CONSTRUCTION PLANS FOR CREEKSIDE AT LORSON RANCH FILING NO. 1 STREET AND STORM SEWER CONSTRUCTION PLANS

Engineering Review

**CREEKSIDE AT LORSON RANCH FIL NO. 1
STREET / STORM SEWER
CONSTRUCTION PLANS**

CASTOR DRIVE

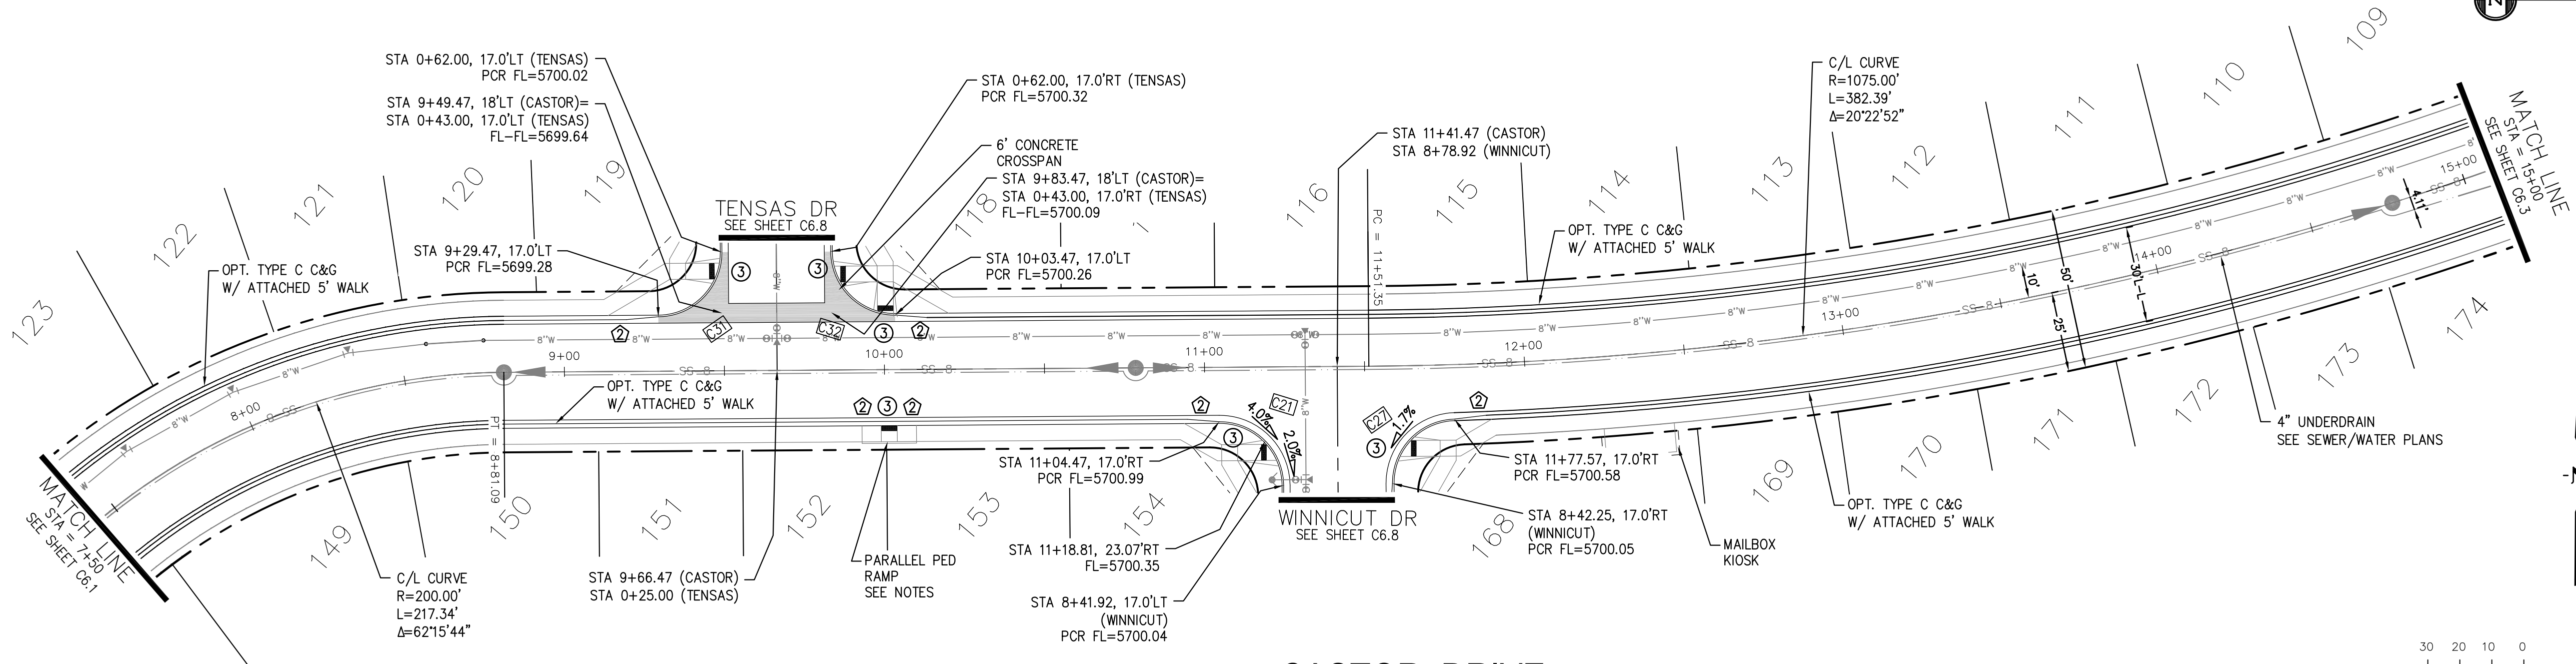
Show sanitary sewer and water profiles grayed out on profiles.
